**WCI Response to Mercer Island Pre-App Notes PRE20-010**

**Rosen, Doug - 5995 SE 30th St**

**NOTE TO MERCER ISLAND:** Please see WCI responses below **in blue**. Please review the following project using the revised Mercer Island Shoreline Master Plan effective 7/9/20. Please note for building review, the plan set size has been changed to 11x17. Thusly, there are only 7 pages (instead of 9) so some of the pre-app notes cite old page references.

EXISTING SITE PLAN

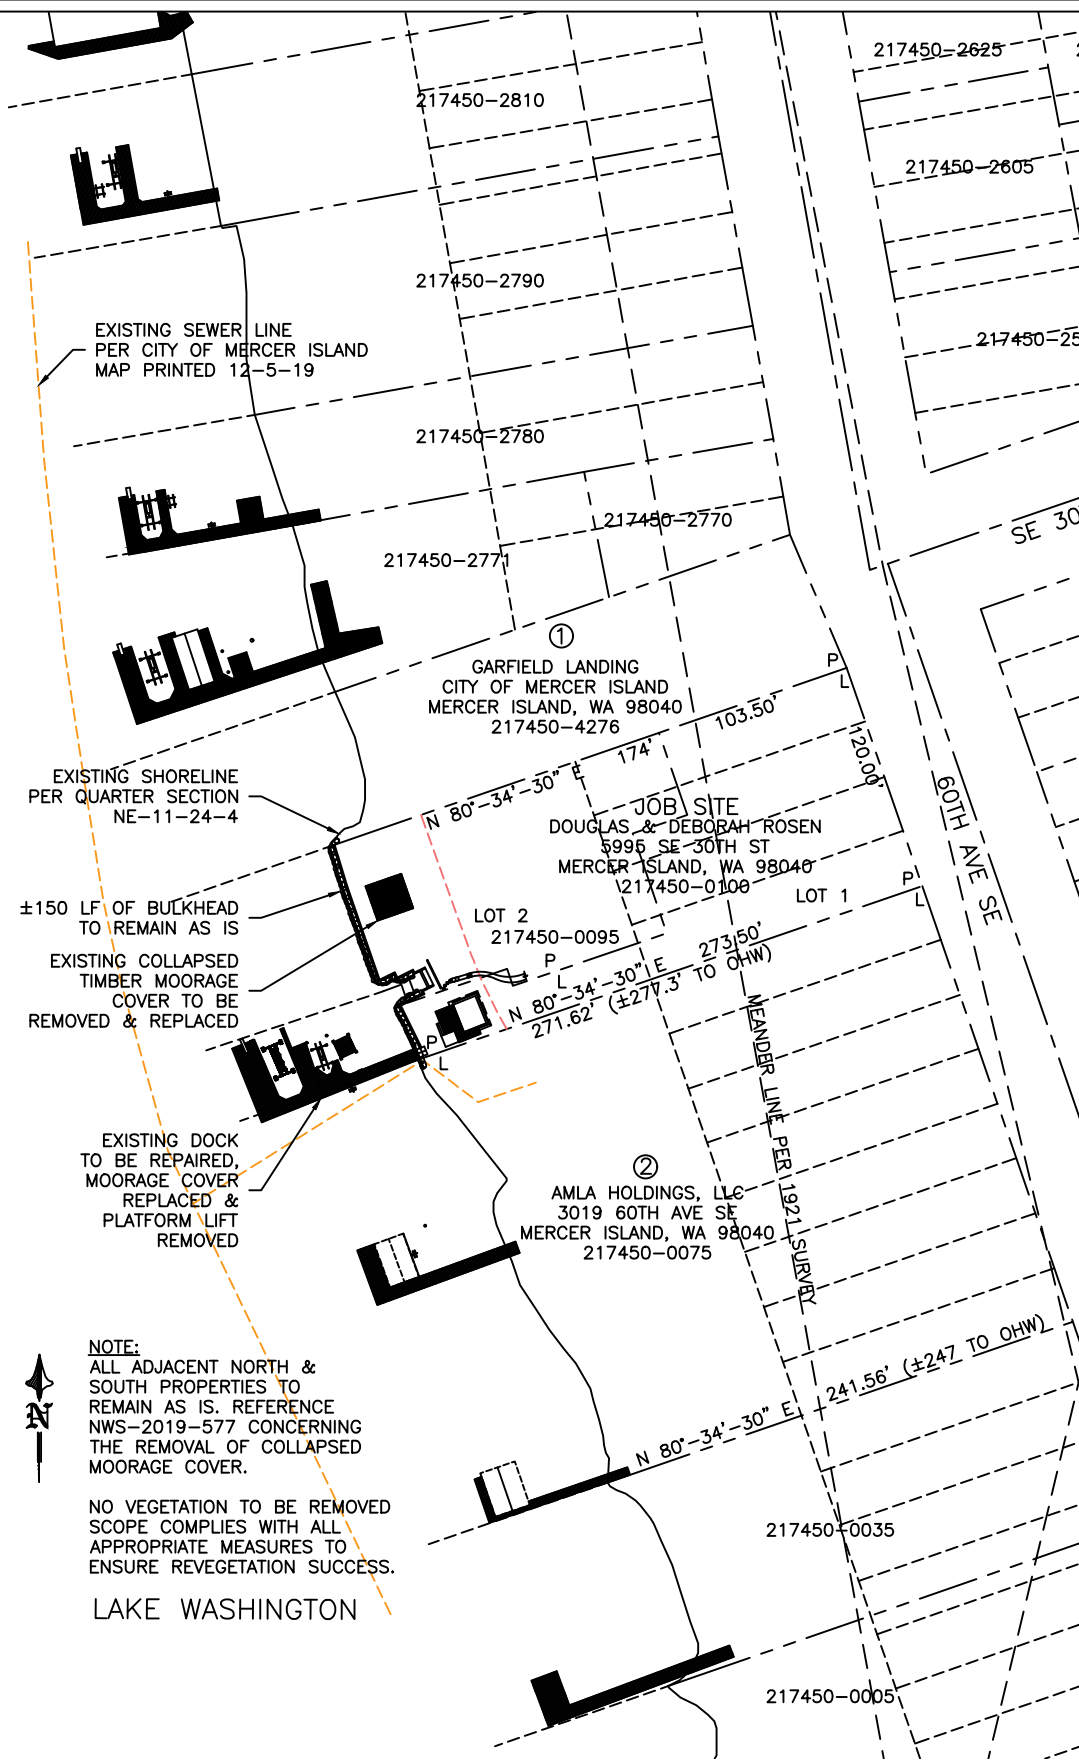
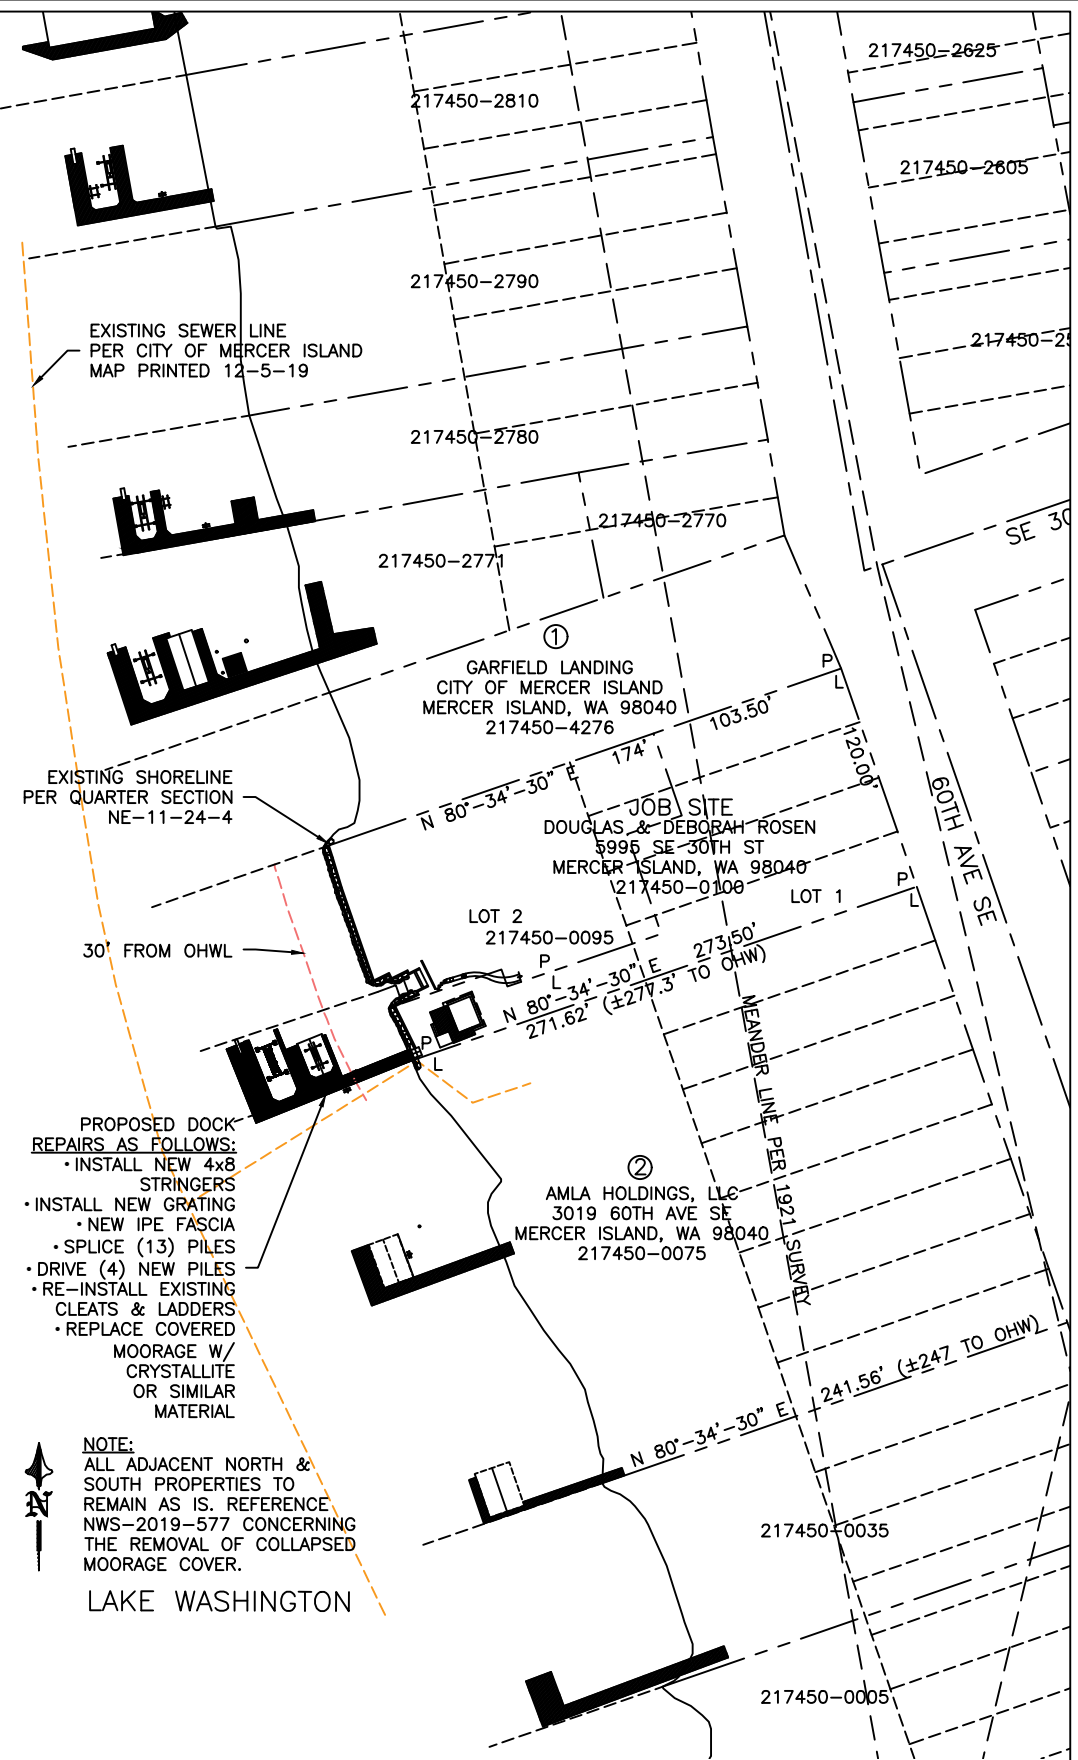
a. All of the sewer easements and recording numbers need to be shown on all sheets within the plan set. This includes easements landward and waterward of the OHWM within the 0- 25 foot setback. If the owner wants to do any shoreline work (e.g. add a pathway, stairs, cove, etc.) it would be best to include it in this application – as that work requires a shoreline permit (shoreline exemption permit usually, but could require an SDP).

b. The estimated sewer lakeline location needs to be shown and labeled on all sheets. The following note needs to be added: “The sewer lakeline will be field verified prior to building permit approval.” The sewer lakeline field location affidavit will be a condition of approval and is required for projects that result in lakebed disturbance. Refer to Attachment A, sewer lakeline condition language and affidavit. Refer to Attachment B, sewer easement locations.

**WCI Response #7:** Note added to page 1 and sewer lake line affidavit also attached (See Exhibit 10).

EXISTING DETAIL VIEW
SCALE: 1/16"=1'

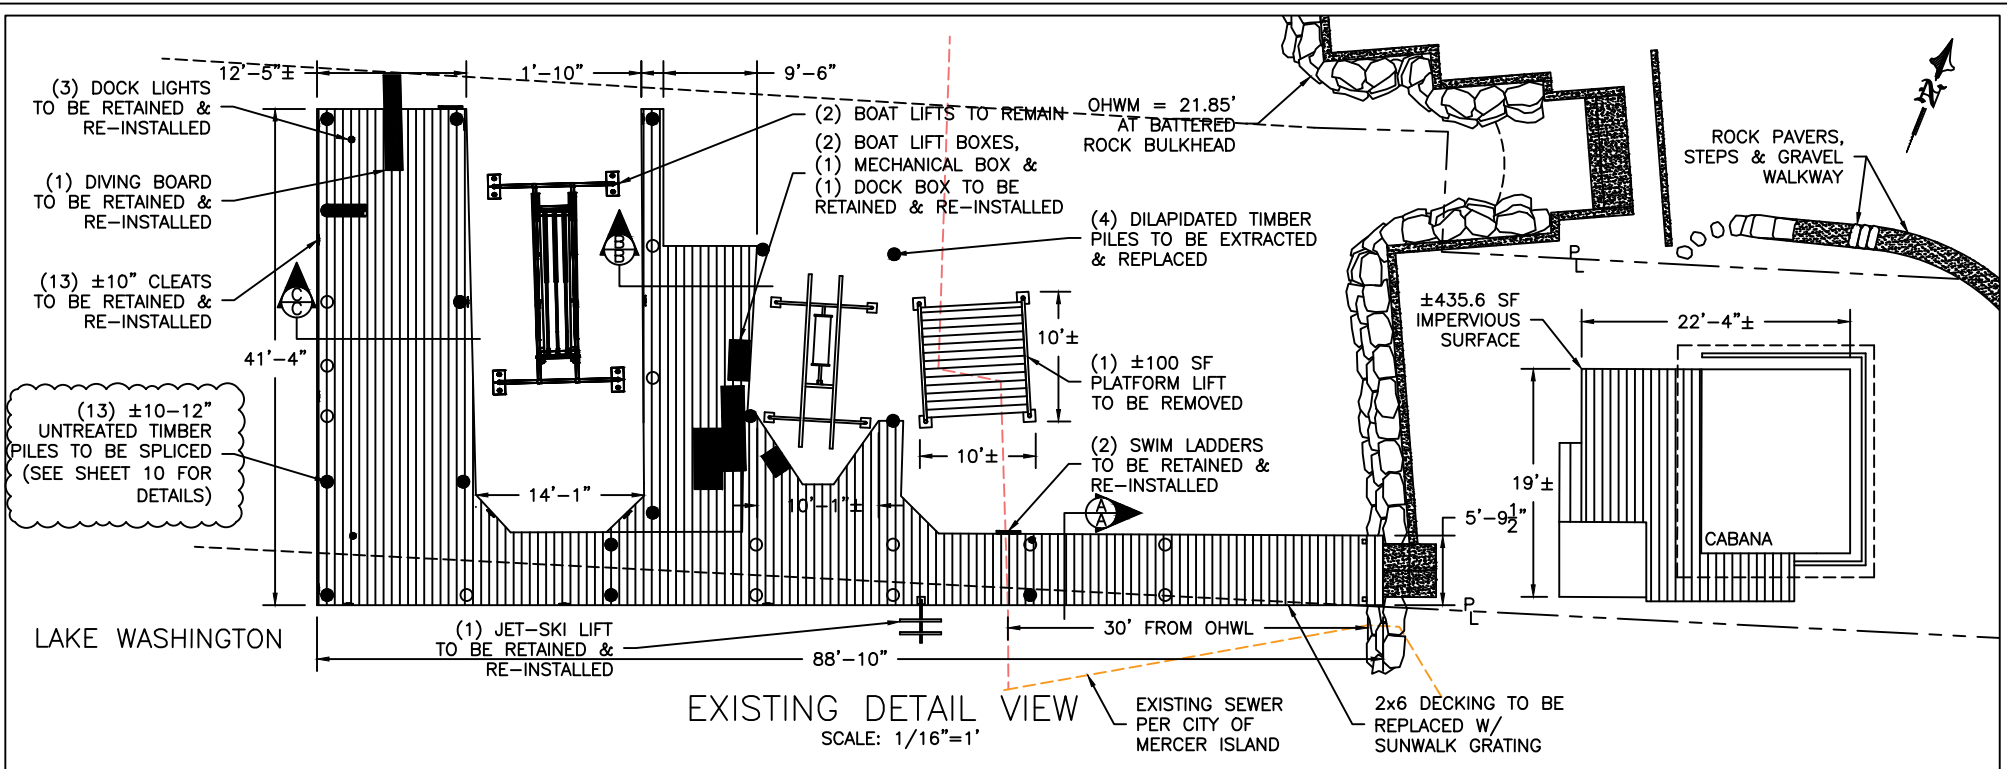
d. The plans (sheet 2 of 10) show the existing collapsed moorage cover on land – please add a note clarifying why it was moved to that location and reference the Emergency Permit #.

**WCI Response #14:** Page 1 of the plan set indicates the collapsed timber moorage cover was removed on USACE permit# NWS-2019-577. Add'l permit details available upon request.

PROPOSED MOORAGE COVER SIDE VIEW

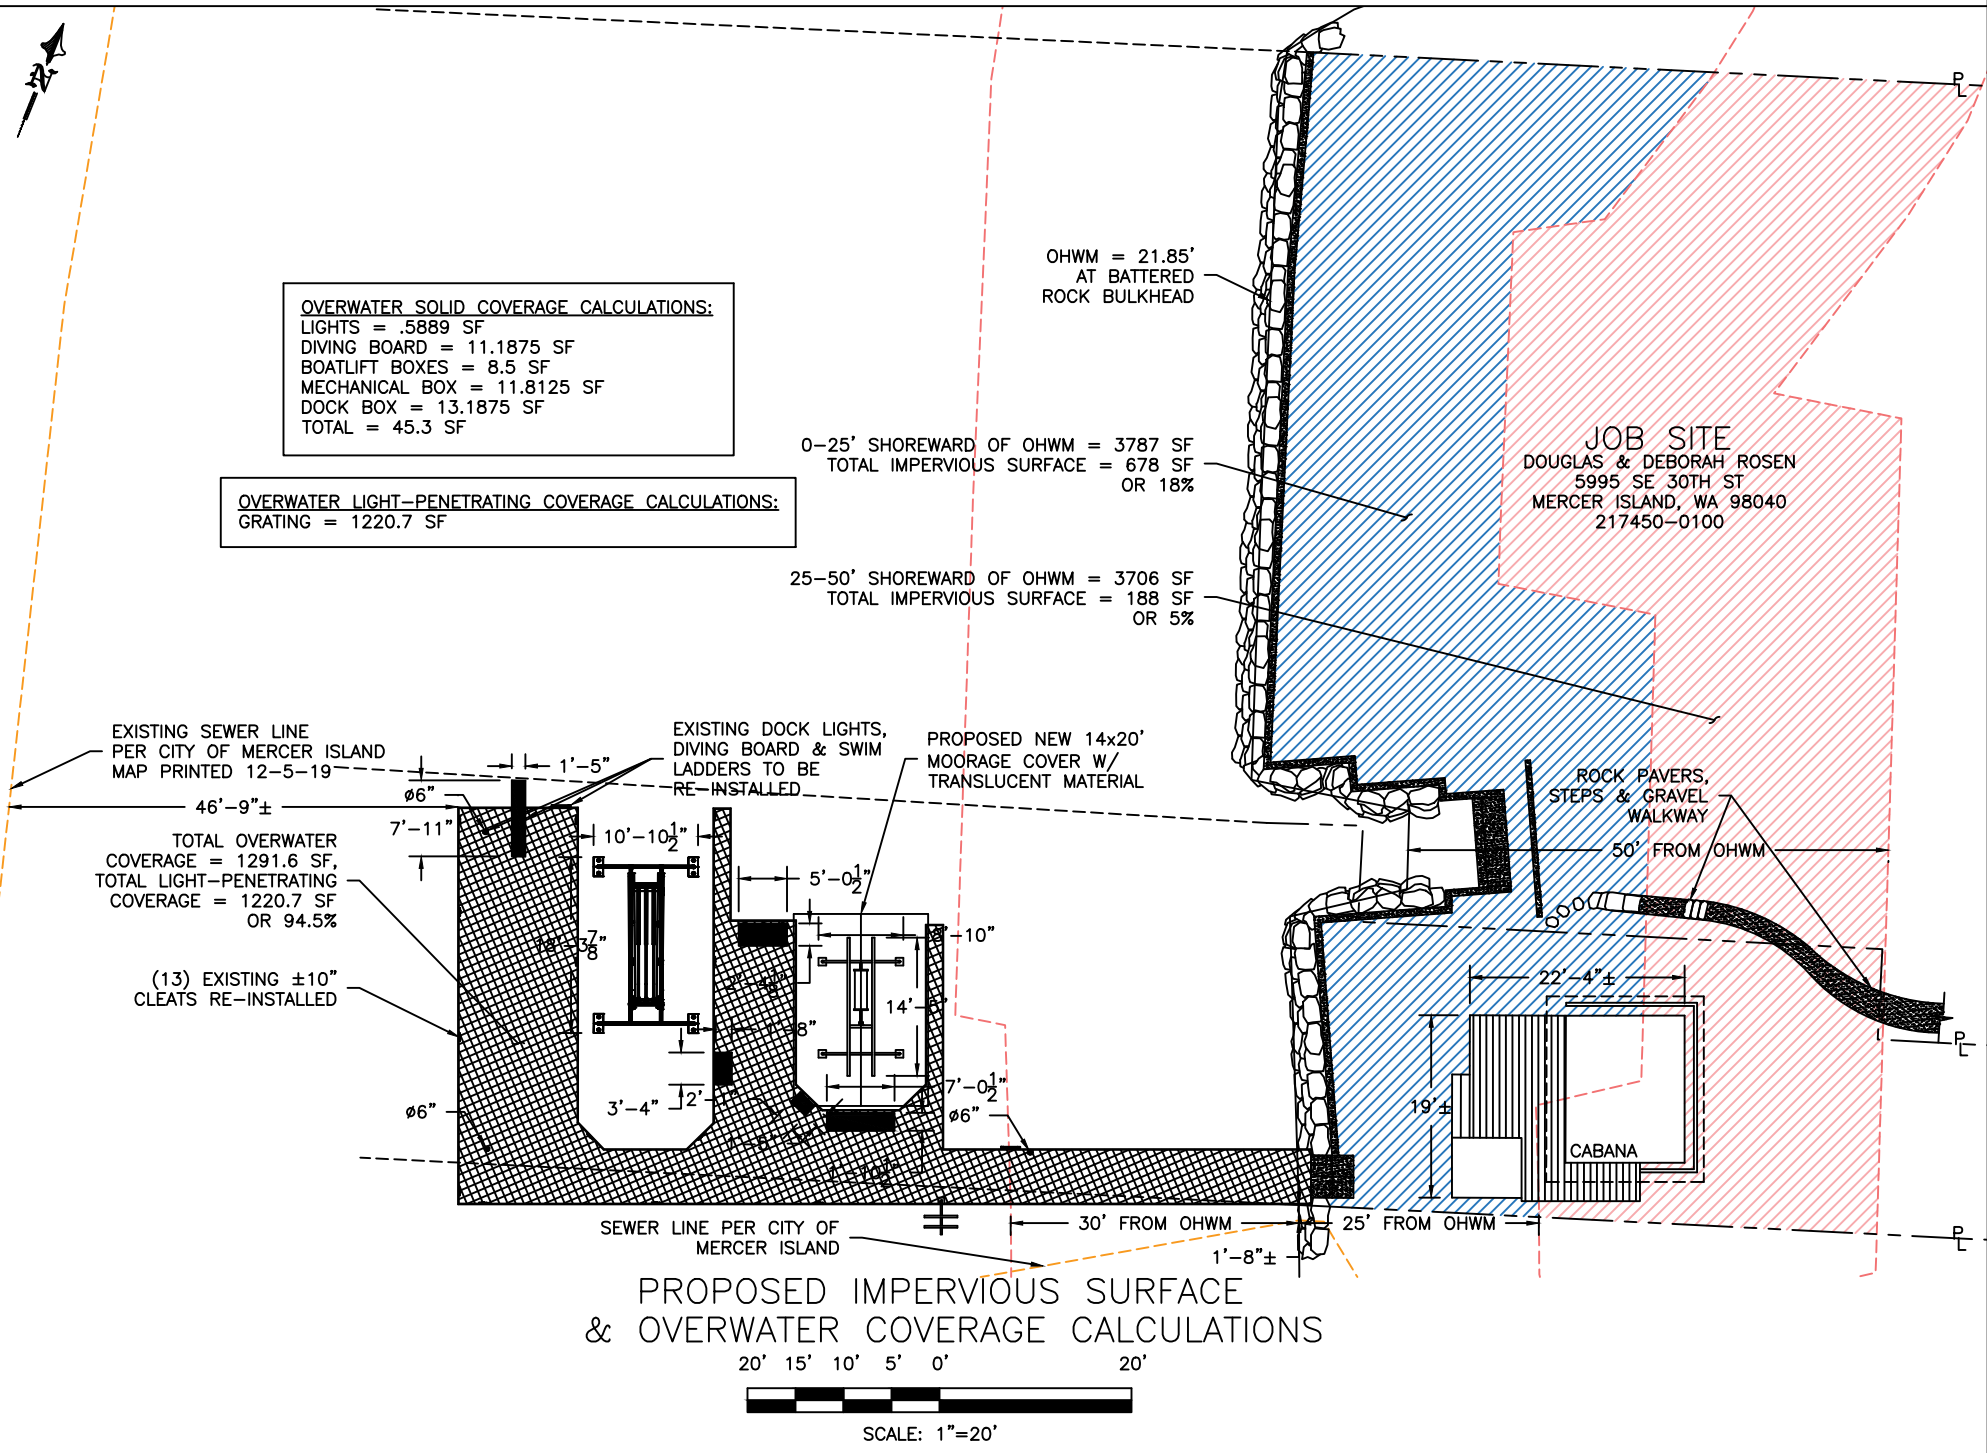
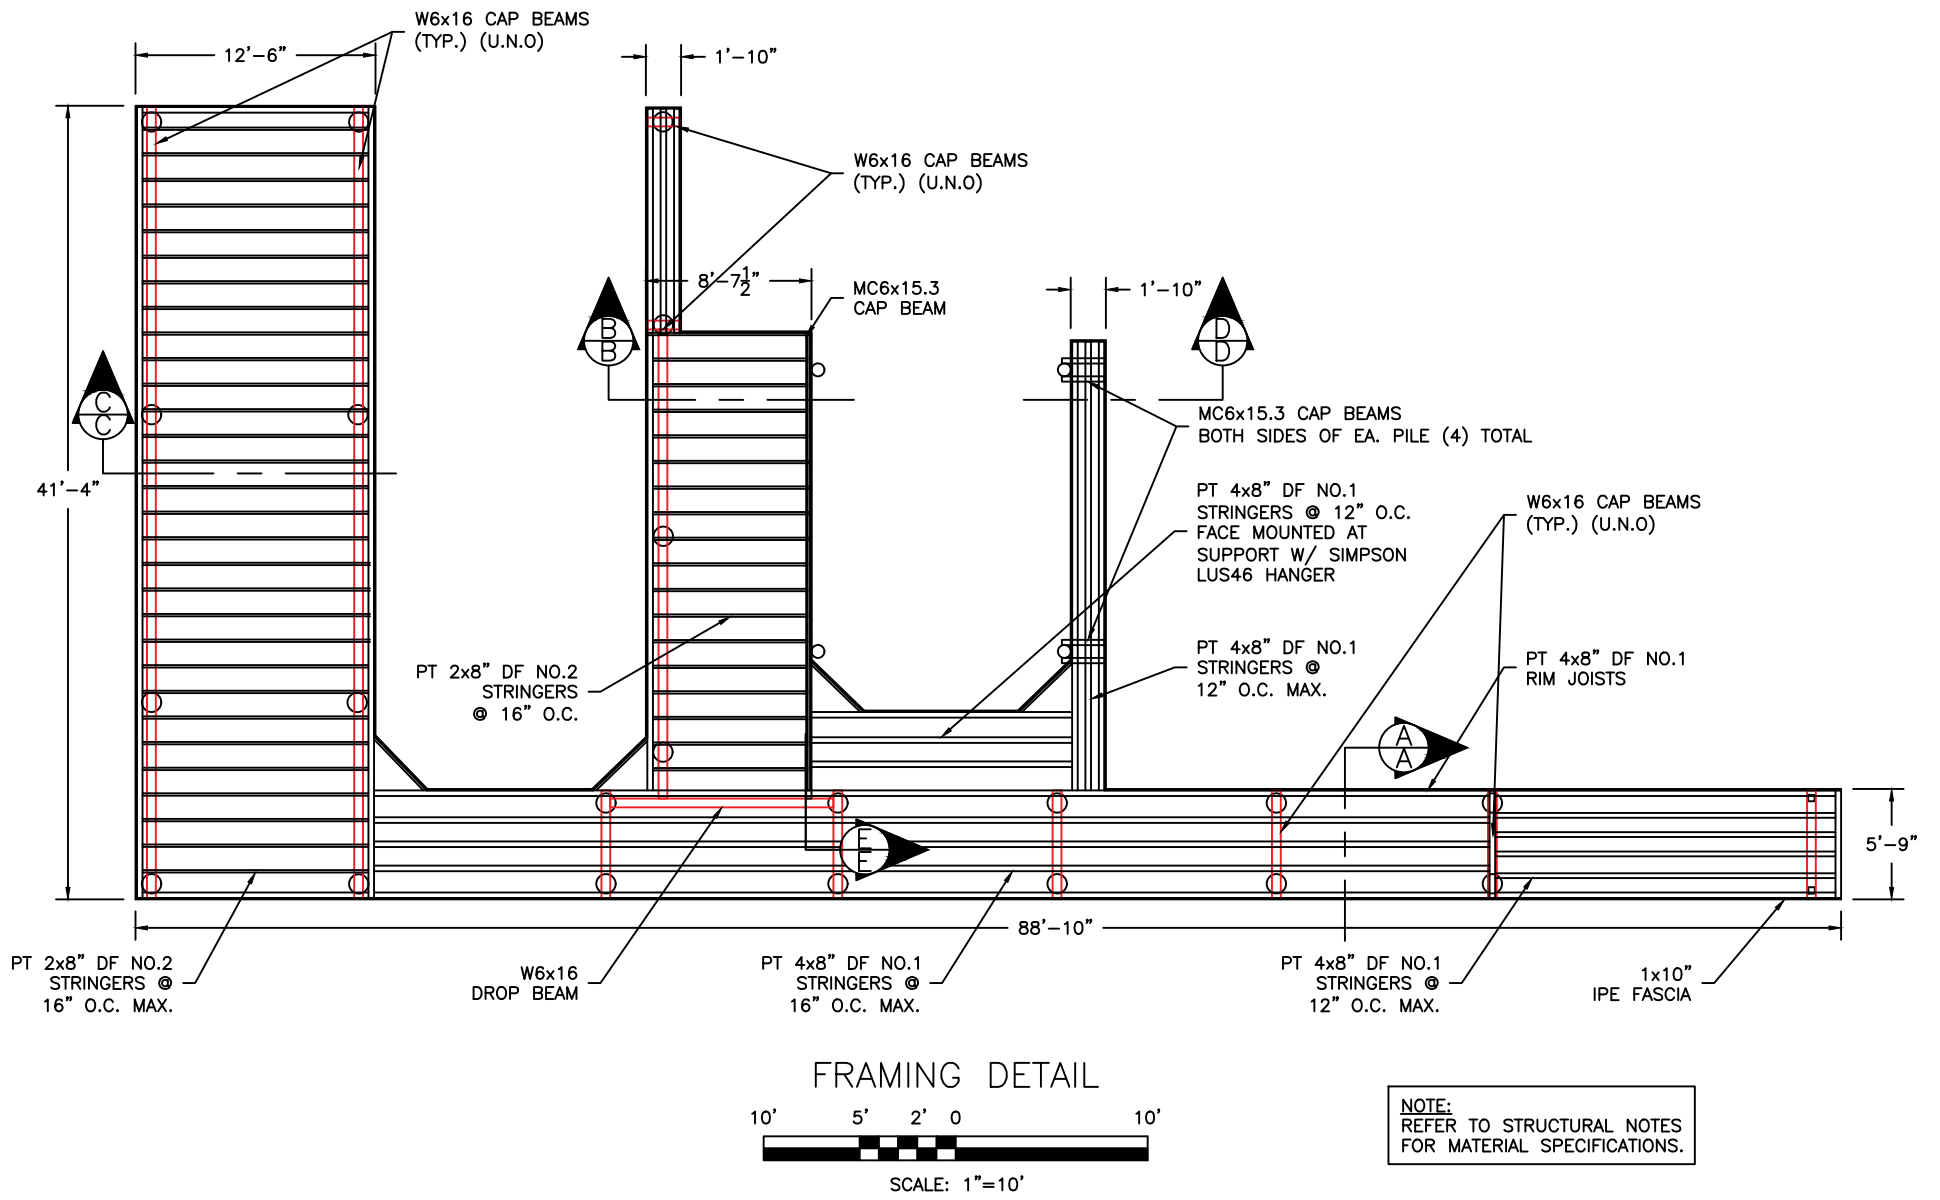
i. The existing boat cover is not a translucent canopy – as seen in Aerial Imagery. The proposed plans indicate that a translucent canopy will be added – please provide more details. Page 9 shows the cover looking more like a roof structure.

**WCI Response #4:** Please see page 5 of the plan set for moorage cover details. CrystaLite translucent panels provide approved-light transferring properties per pervious DFW, NOAA and USACE approvals. Please see Exhibit 9 for more details on moorage cover materials.
